DELEGATED HOUSEHOLDER DECISION

Item No.	Report of the Head of Planning, Sport and Green Spaces	
Address	48 HARLYN DRIVE PINNER	
Development:	Two storey rear extension, single storey side extension with front extension infill and alterations	
LBH Ref Nos:	4956/APP/2015/789	
Drawing Nos:	12/15 (Existing and Proposed Block Plans) 12/15 (Existing Elevations) 12/15 (Existing and Proposed Floor Plans) 12/15 (Proposed Elevations) Location Plan (1:1250)	
Date Plans Received:	04/03/2015	Date(s) of Amendment(s):
Date Application Valid:	13/03/2015

The application is for the erection of a two storey rear extension, a single storey side extension with front extension infill and alterations.

DWG NO: 12/15

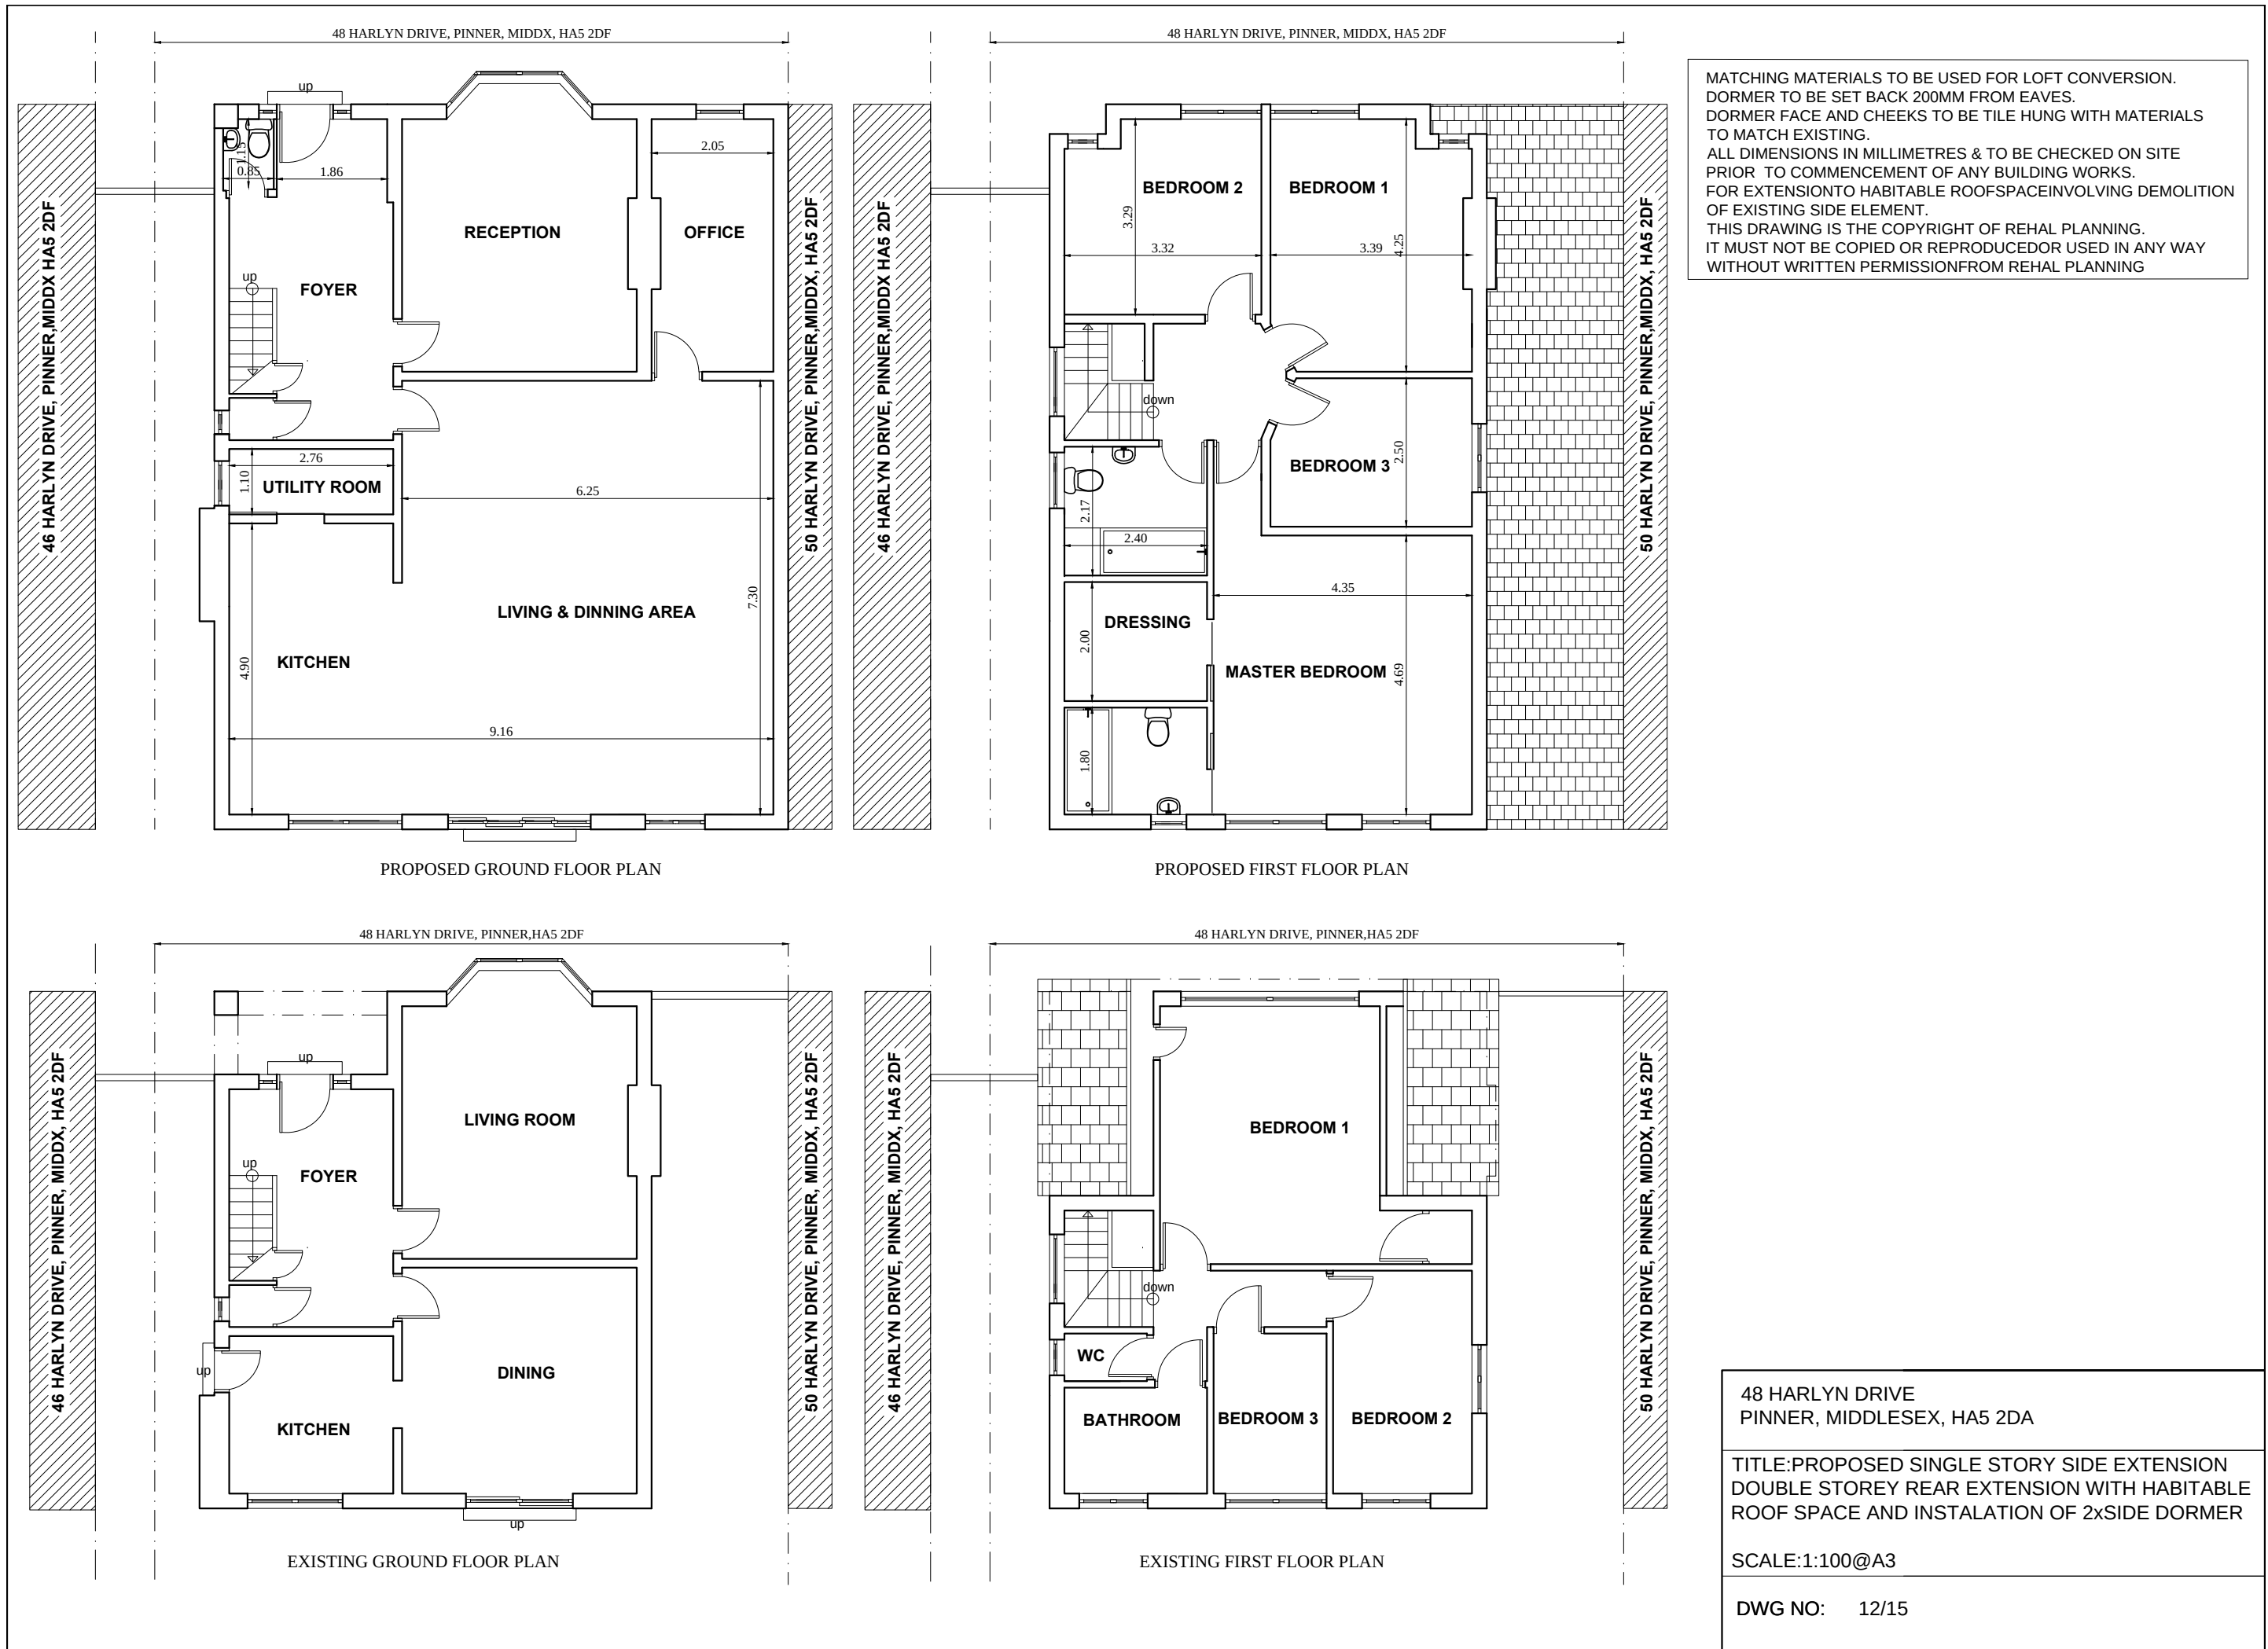
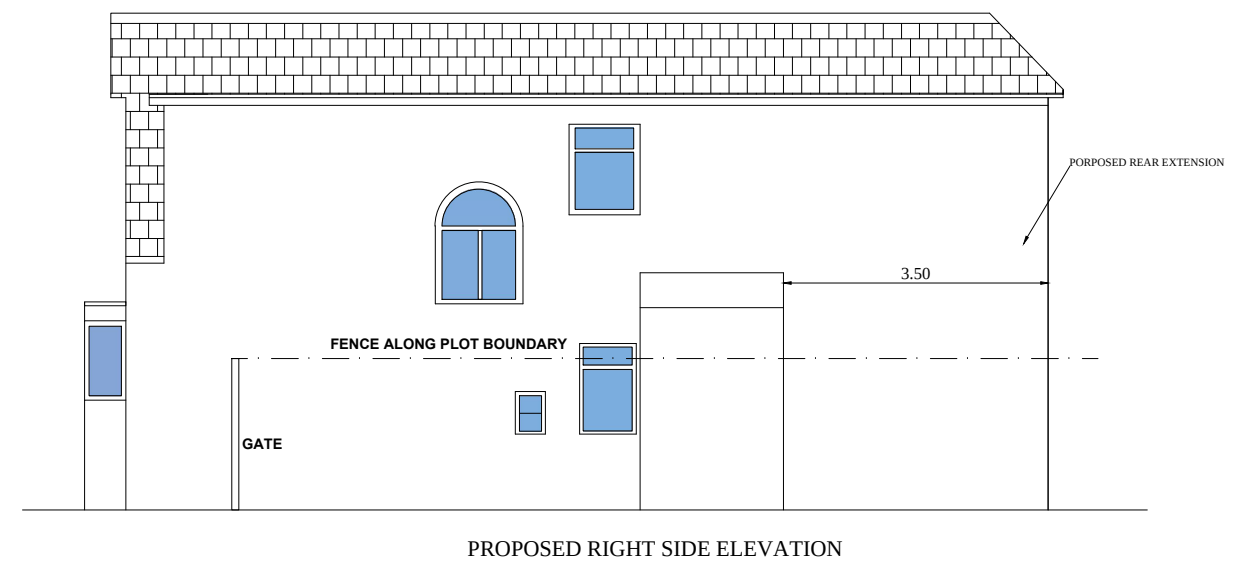
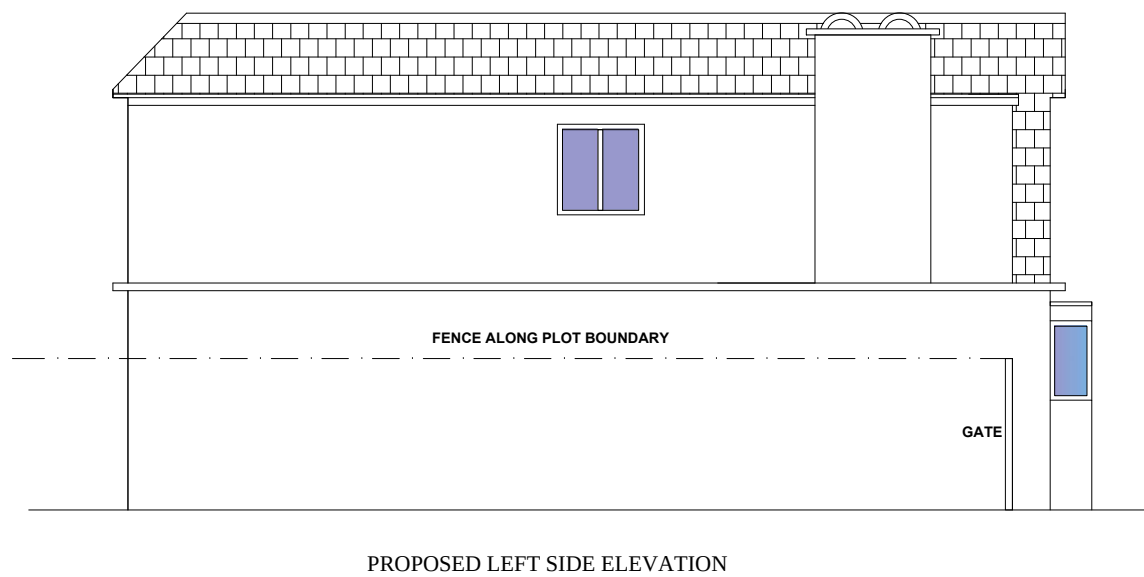
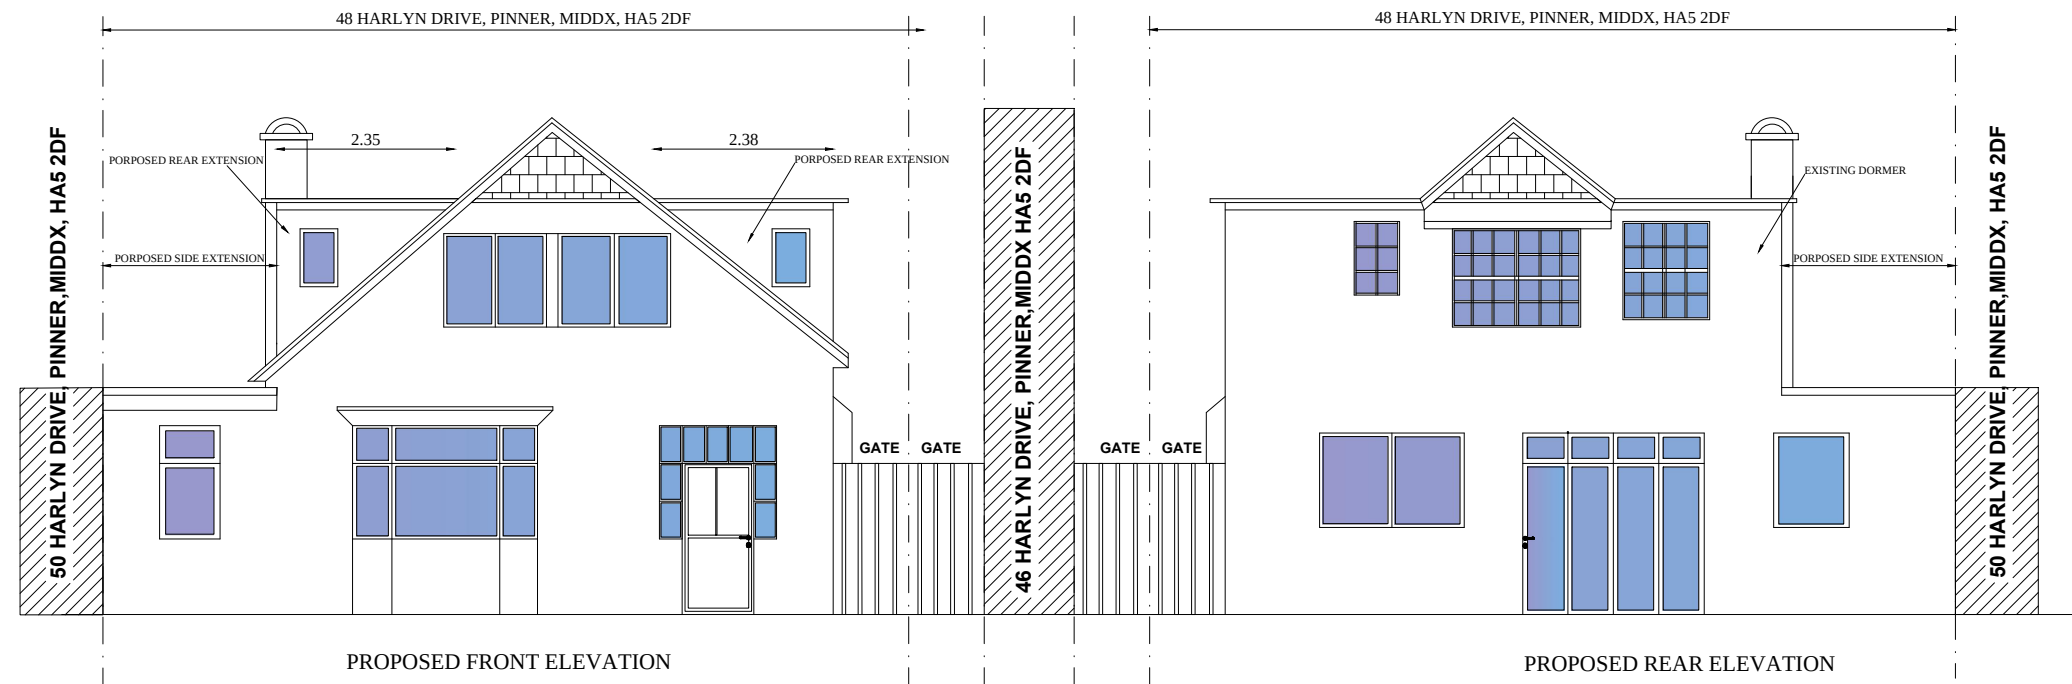
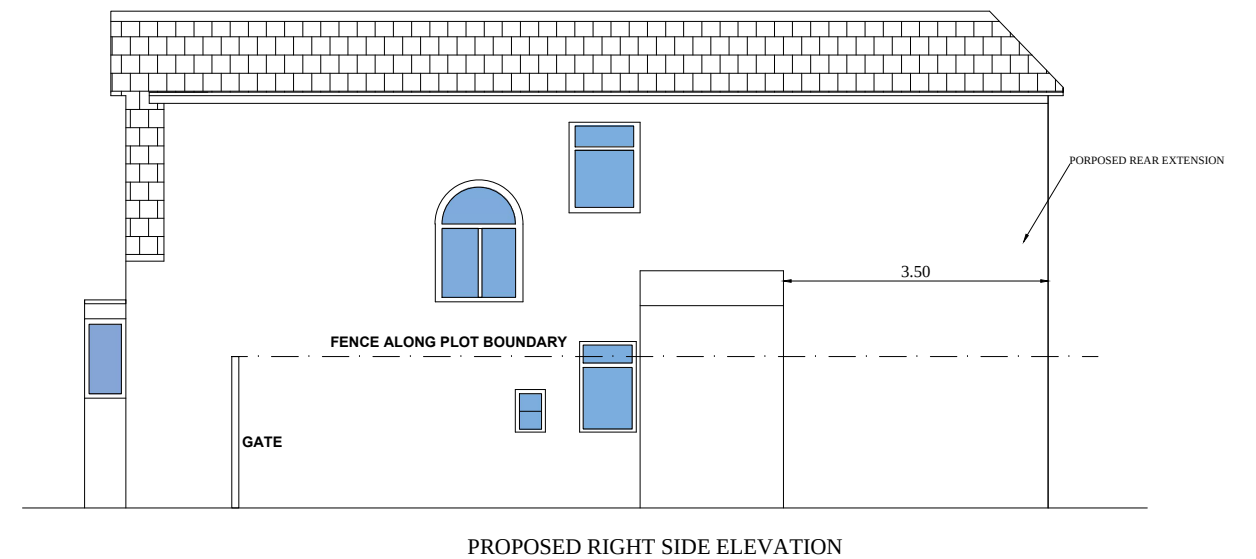
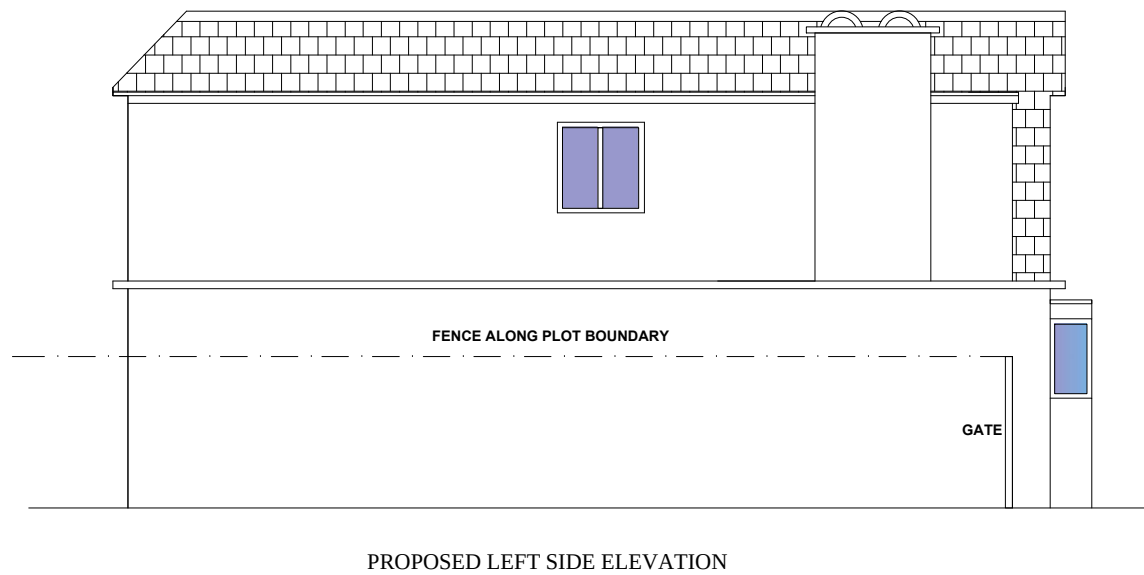
The proposed single storey side extension measures 2.3m in width, 12.2m in length, including a projection beyond the existing rear elevation of 3.5m and has a flat roof of 3m in height. The proposed two storey rear extension measures 3.5m deep and 6.6m wide

(including across the side extension) and has a roof height to match the existing. The proposed first floor side extensions is set into the roof slope and is 2.55m in width, 11.7m long (set back 0.5m from the front elevation) and has a flat roof of 1.9m in height, incorporating the existing 5.25m long side extensions at the rear of the existing dwelling.

These are sizable extensions, particularly the first floor side extensions, which are clearly visible from the street scene and are considered to be unduly bulky and over dominant. It is acknowledged that there are existing side extensions on the property however these are setback from the front elevation and are not so visually dominant. It is also noted that this form of development has taken place on other properties in the street, including the neighbouring property, however these are not recent approvals and only serve to demonstrate how visually intrusive and unsympathetic this form of development is. As such it is considered that the proposal fails to comply with the requirements of Policies BE13, BE15, BE19 and BE21 of the Hillingdon Local Plan: Part Two - Saved UDP Policies (November 2012) and HDAS - Residential Extensions.

There are no proposal additional side windows at first floor level and the proposed rear windows will match the existing. It is therefore considered there will be no increase in overlooking or loss of privacy to neighbouring properties as a result of this proposal. However HDAS advises that two storey rear extensions will only be allowed where there is no significant over-dominance, over shadowing, loss of outlook and daylight. The proposal compromises the 45 degree line of sight from the upper floor habitable room window to the neighbouring property, no 50 and would thus have an unacceptable impact on the amenities of this property contrary to Policies BE19, BE20 and BE21 of the Hillingdon Local Plan: Part Two - Saved UDP Policies (November 2012).

The proposed two storey rear extension, by virtue of its size, scale, bulk and proximity, would be detrimental to the amenities of the adjoining occupier at 50 Harlyn Drive, by reason of visual intrusion, overdomination, loss of daylight, loss of sunlight, overshadowing and loss of outlook. Therefore the proposal would be contrary to Policies BE19, BE20 and BE21 of the Hillingdon Local Plan: Part Two - Saved UDP Policies (November 2012) and the Council's adopted Supplementary Planning Document HDAS: Residential Extensions.

The proposed two storey rear extension and first floor side extensions, by virtue of their size, scale, bulk and design would be detrimental to the architectural composition, character and appearance of the existing dwelling and the visual amenity of the wider area. Therefore the proposal would be contrary to Policy BE1 of the Hillingdon Local Plan: Part One - Strategic Policies (November 2012), Policies BE13, BE15 and BE19 of the Hillingdon Local Plan: Part Two - Saved UDP Policies (November 2012) and the Council's adopted Supplementary Planning Document HDAS: Residential Extensions.
